**From:** Jennifer Thompson  
**To:** Jean Fraser  
**Date:** 4/10/2014 8:52 AM  
**Subject:** Fwd: Re: 118 condo documents- City comments

**From:** Jean Fraser <JF@portlandmaine.gov>  
**Date:** Monday, April 7, 2014 10:59 AM  
**To:** Tom Federle <tom@federlemahoney.com>  
**Cc:** 'Ed Theriault' <etheriault@e-tla.com>, <chip@newheightgroup.com>  
**Subject:** 118 condo documents- City comments

I refer to the ""Public Offering Statement" and various sections and exhibits that you sent to us on March 26, 2014. These are generally fine but we have a couple of comments from the Associate Corporation Counsel:

SUBDIVISION RECORDING PLAT
C1.0

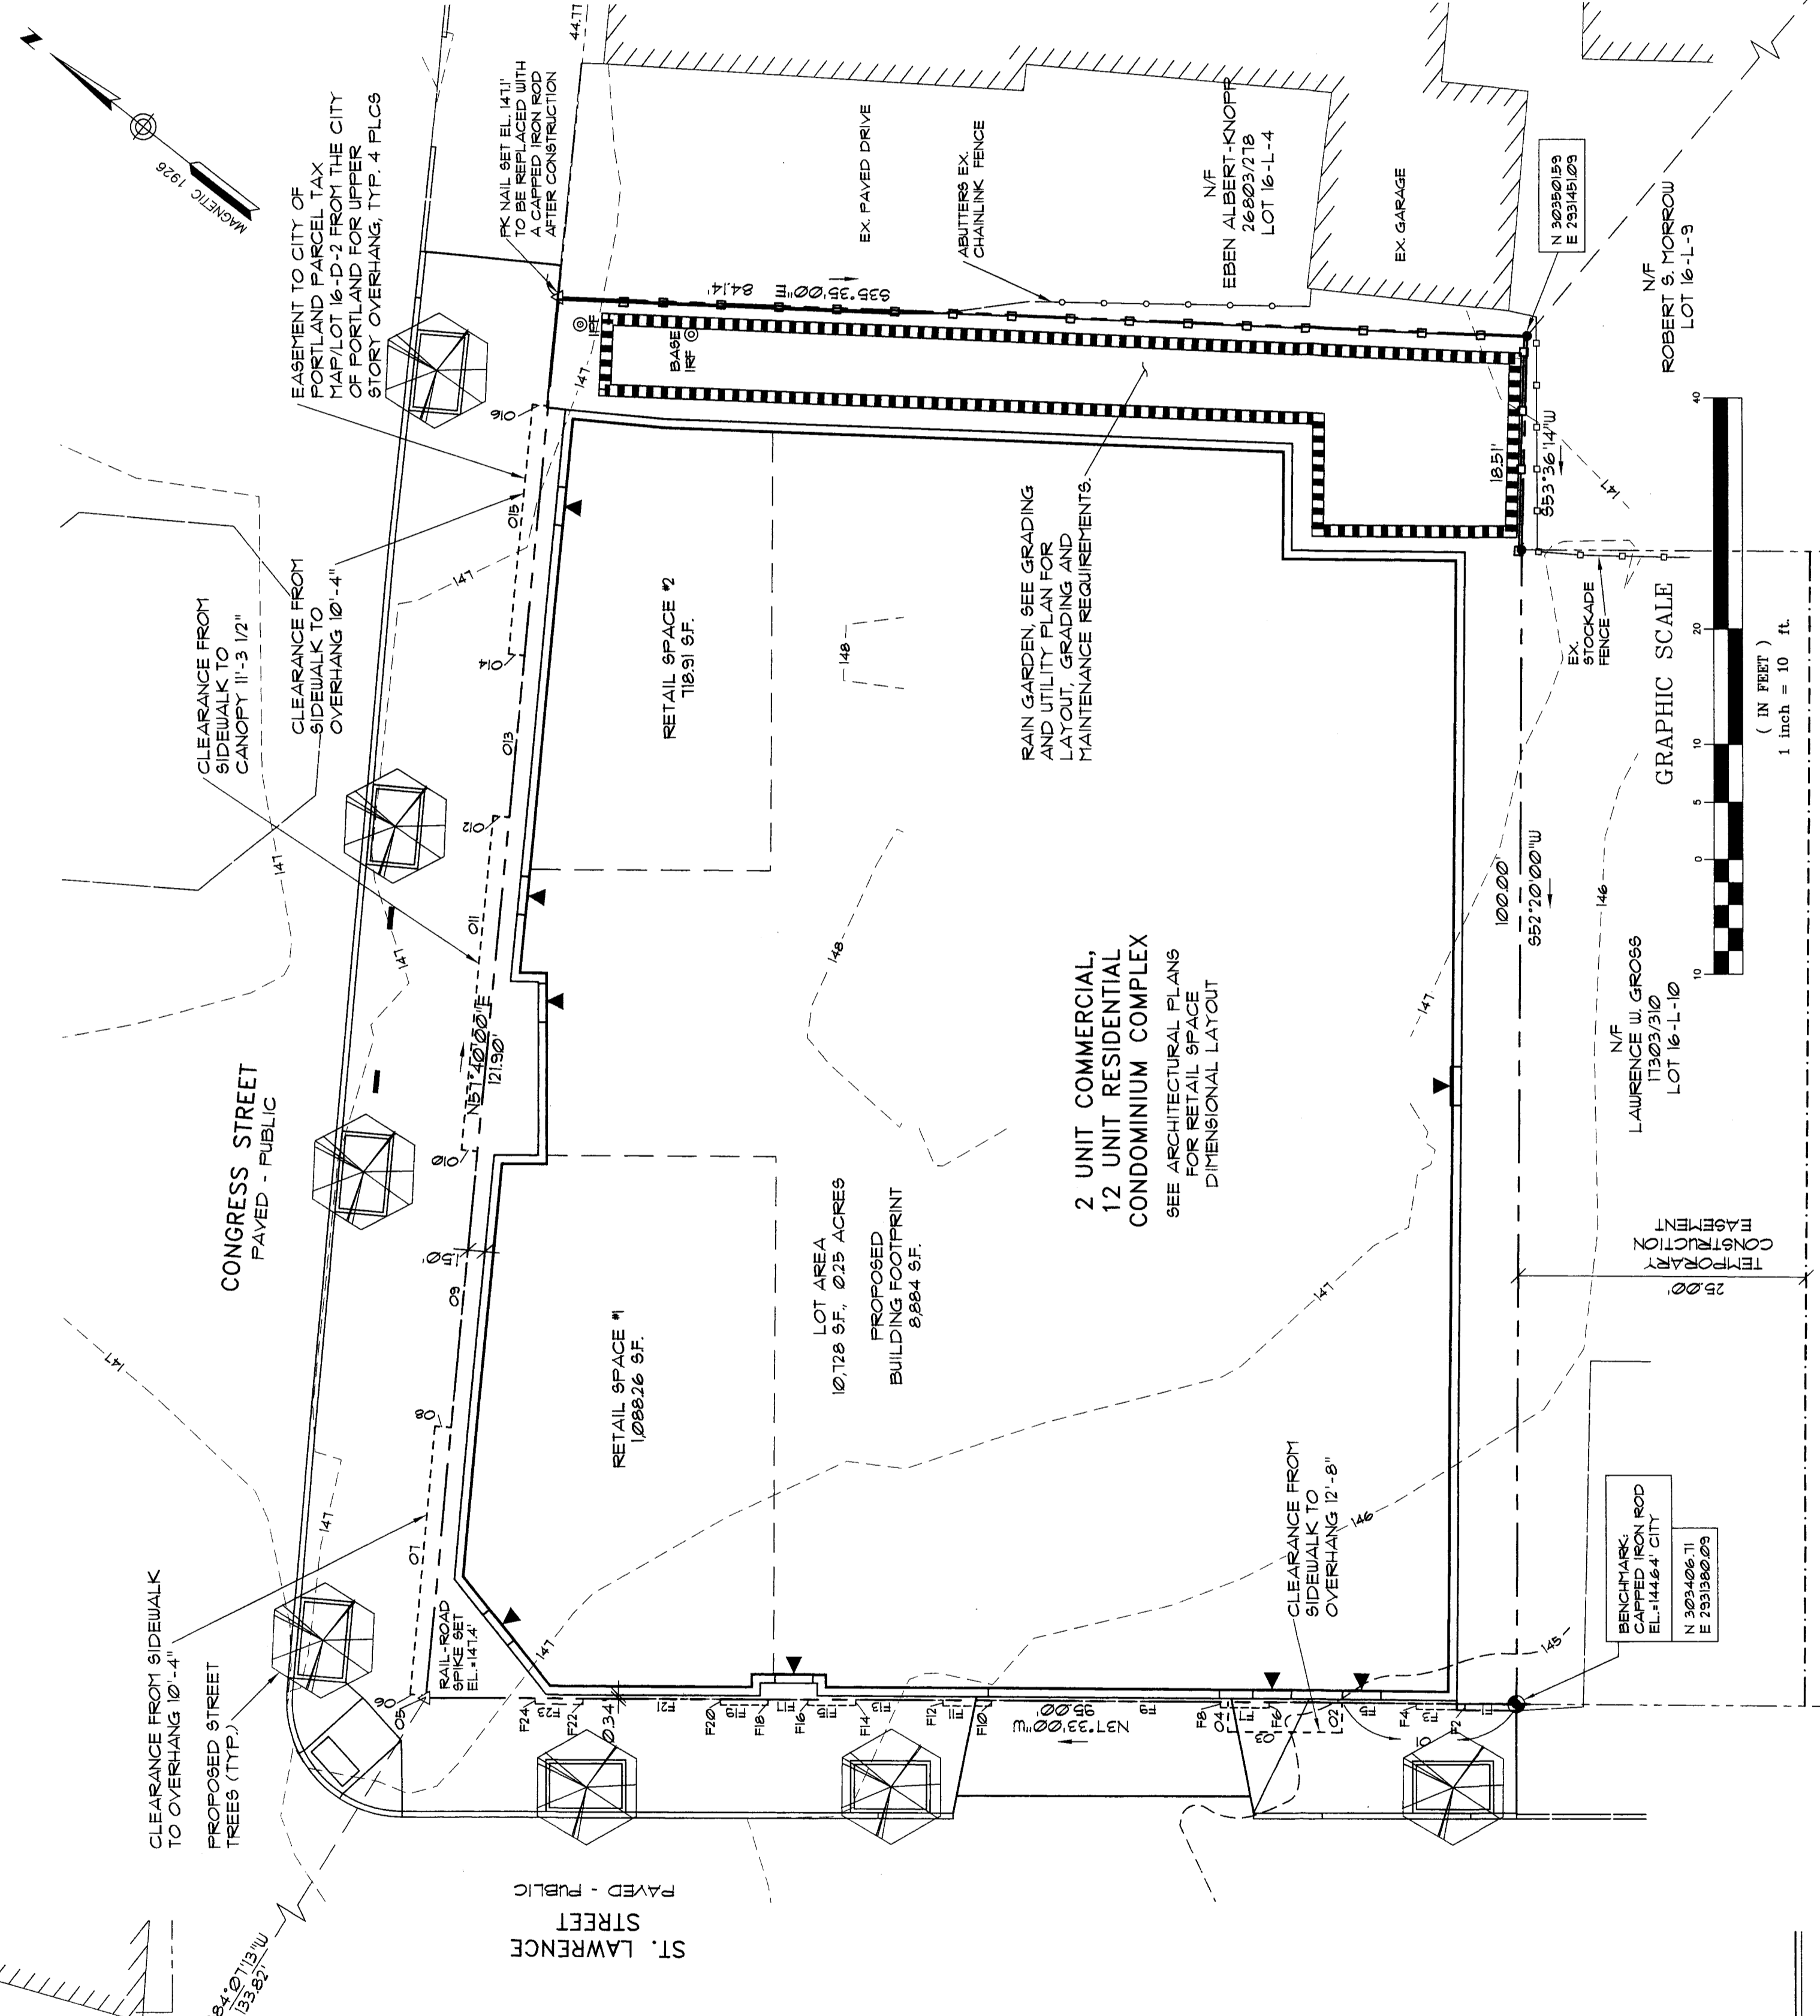
**Exhibit A:** PI note earlier comment that this Subdivision Plat is a draft and should not be labelled as 'approved'. We have a number of substantive comments on the draft Plat which will be forwarded later today to Tom Greer.
